**Byers Gill Solar
EN010139**

8.16 Comments on Deadline 3 Submissions

Deadline 4 – October 2024

ARUP
Redheugh House, Teesdale South, Thornaby Place
Stockton on Tees, TS17 6SG, United Kingdom
Tel +44 (0)131 331 1999 Fax +44 (0)131 331 3730
www.arup.com

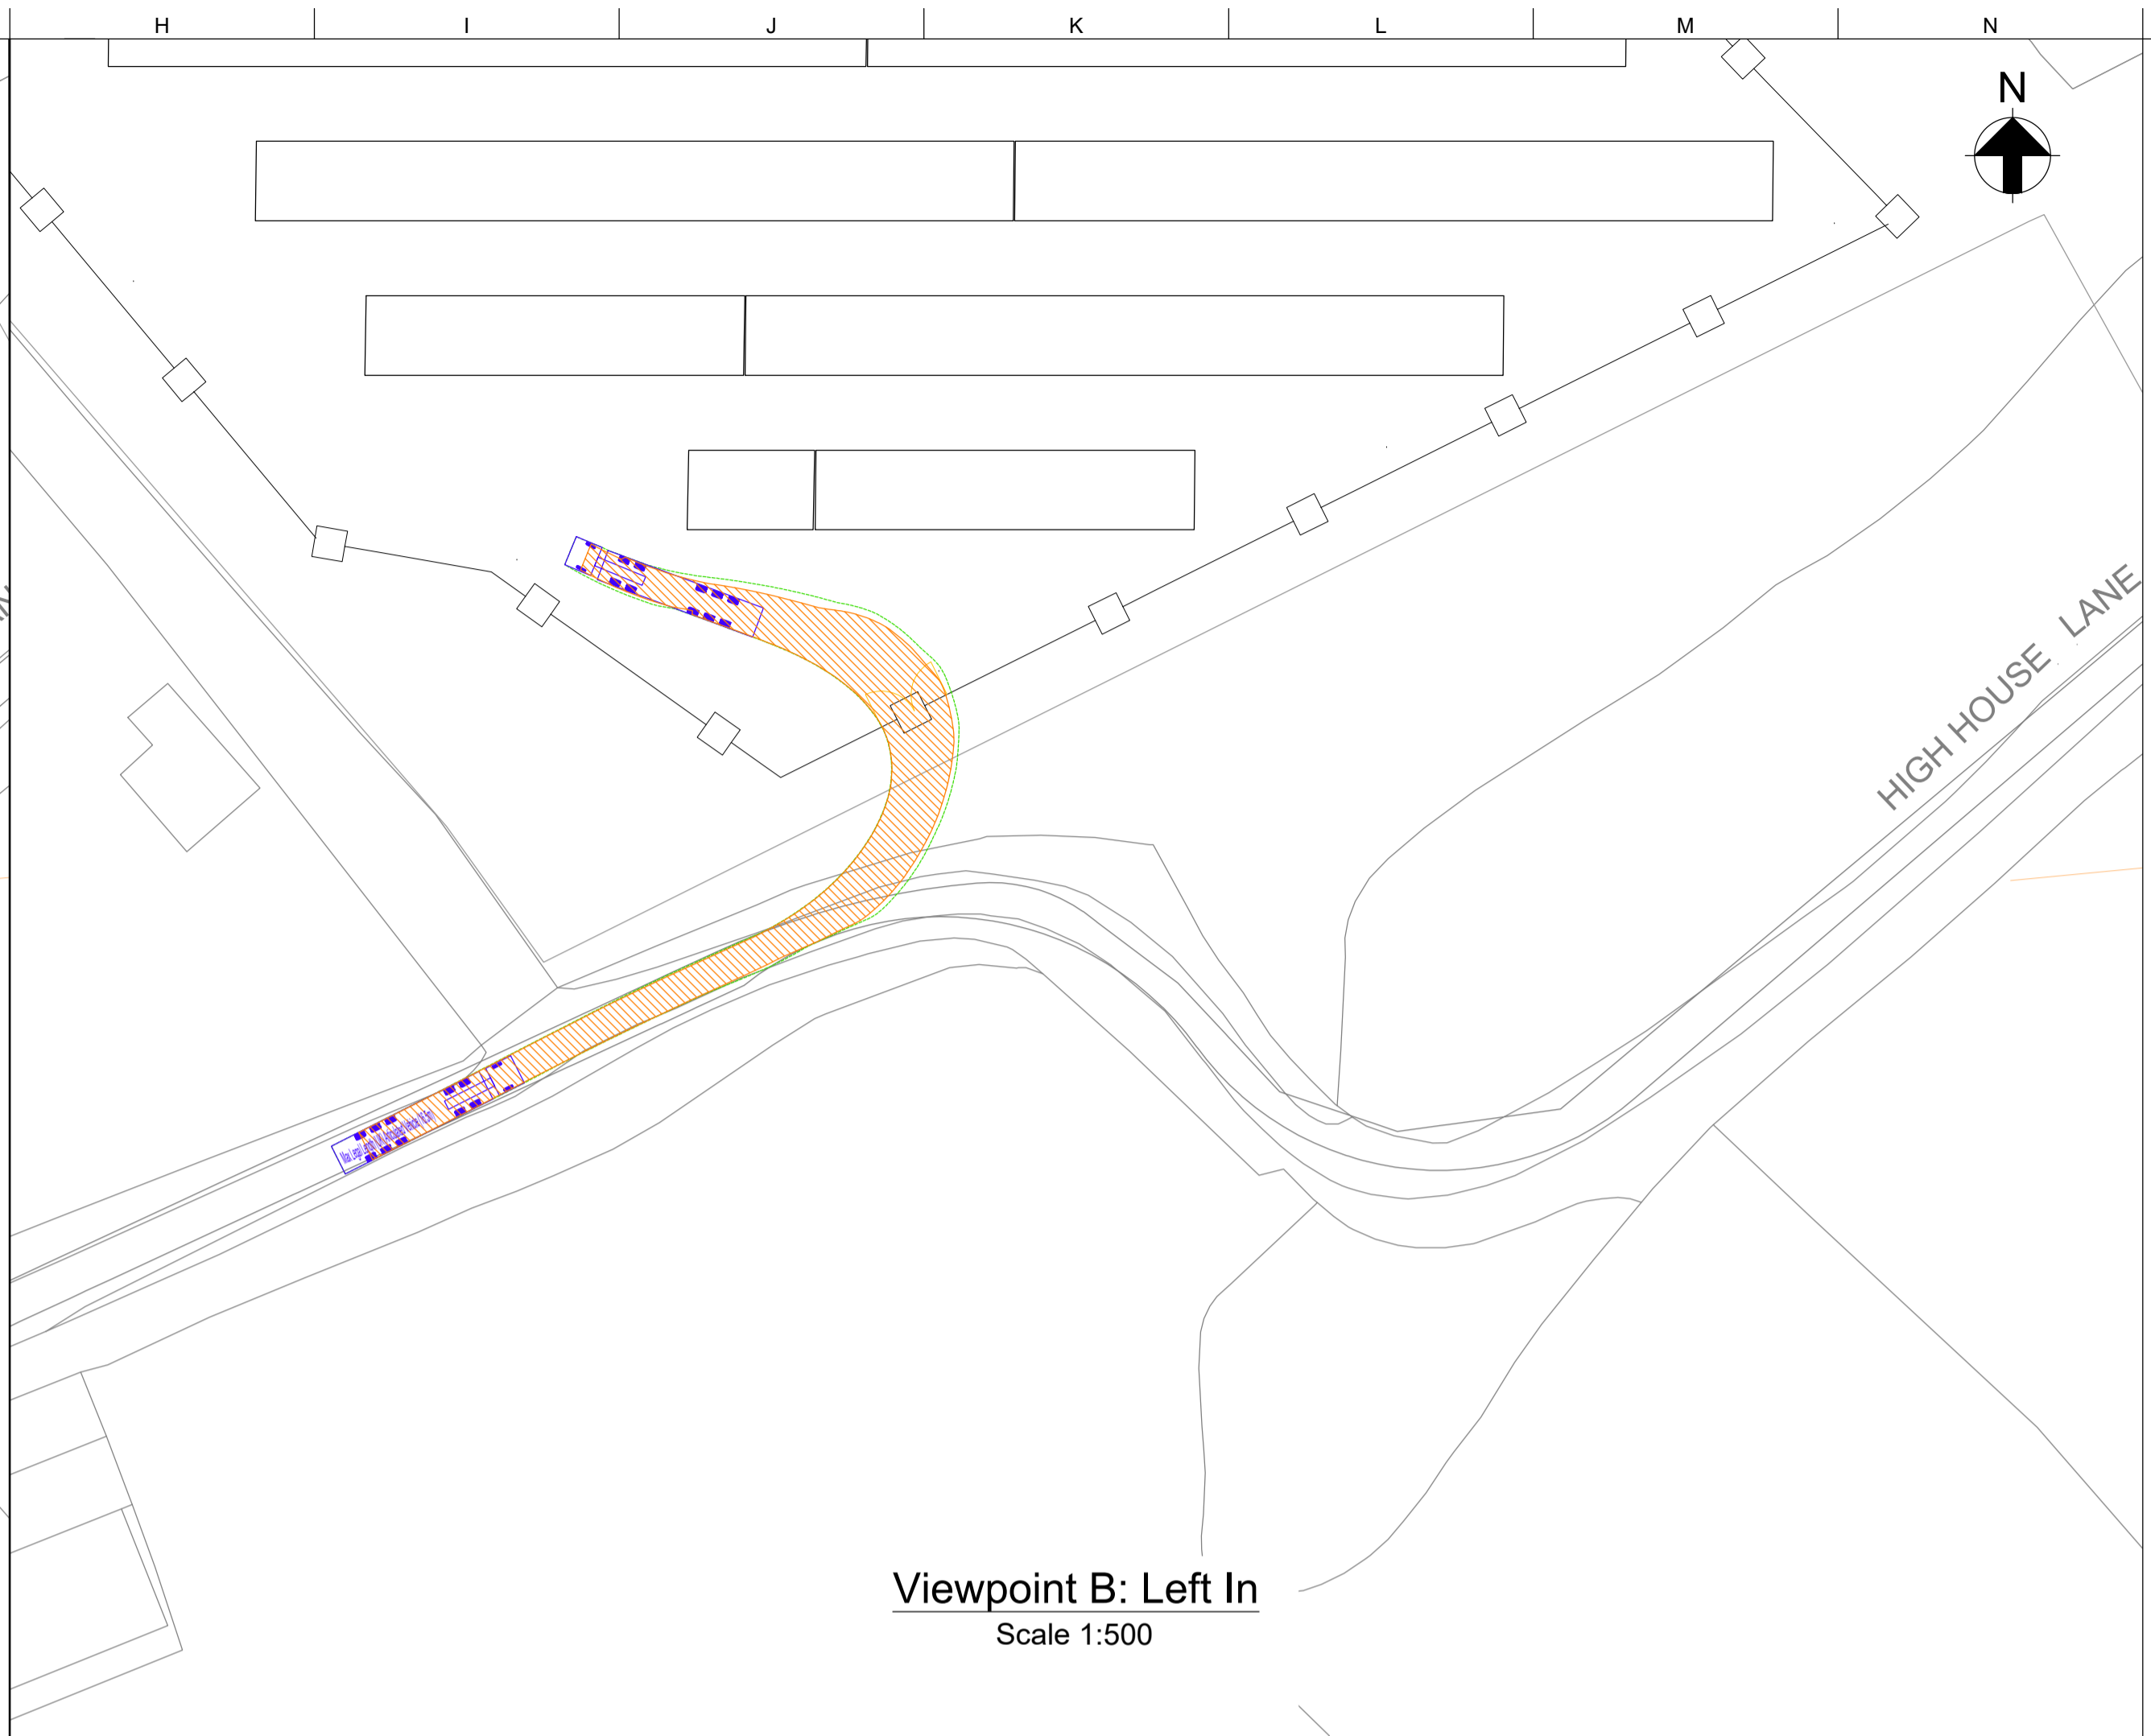
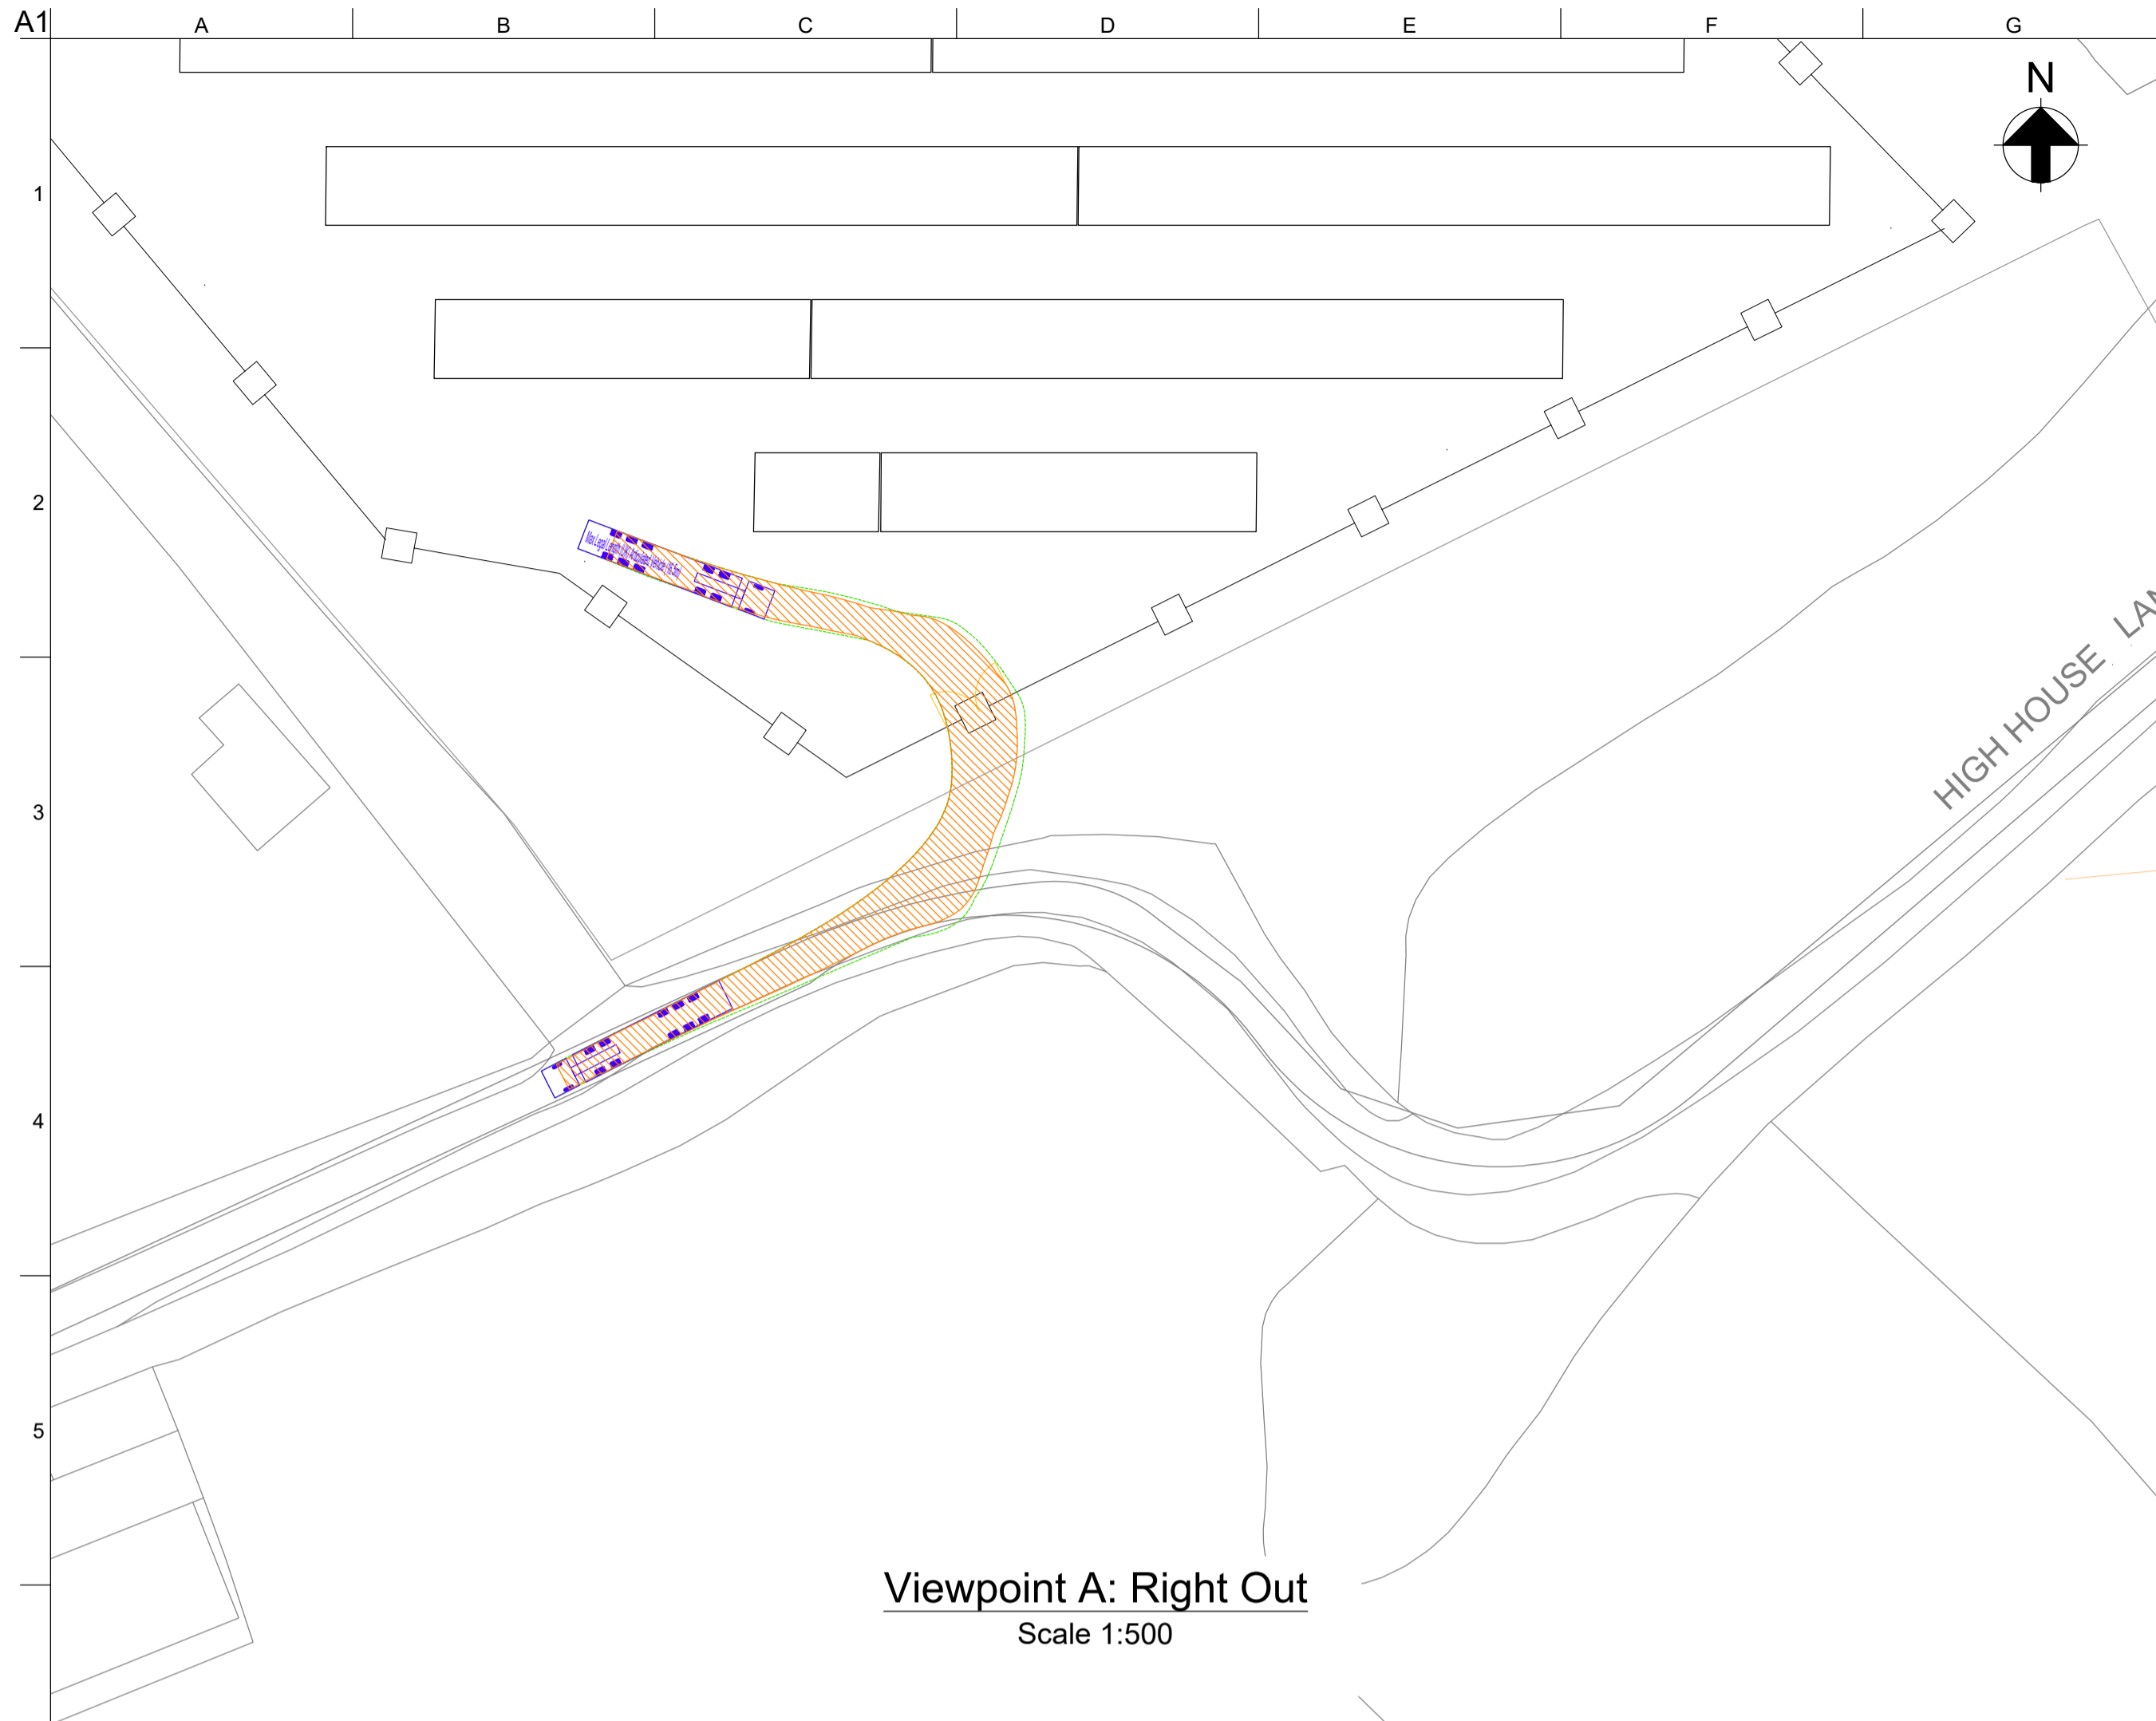
REP3-016	Bishopton Villages Action Group (BVAG)	In relation to ExQ1 TT.1.23, BVAG raise concern regarding proposed site accesses, particularly to Panel Area A.	The Applicant notes BVAG's concerns regarding the access to Panel Area A, referencing BVAG's Landscape & Visual Review [REP2-044]. Comments have been provided regarding this in the submitted document Comments on Written Representations REP2-042 (Bishopton Villages Action Group) and REP2-044 (Landscape & Visual Review) [REP3-005]. The Applicant considers the accesses to be sufficient, with detailed design to be developed post-consent. However, as discussed at the Issue Specific Hearing 2 on 15 October 2024, the Applicant and Darlington Borough Council Highways Department have been in recent discussion on the accesses, including sharing of visibility splays. An update on these discussions is expected by Deadline 5.
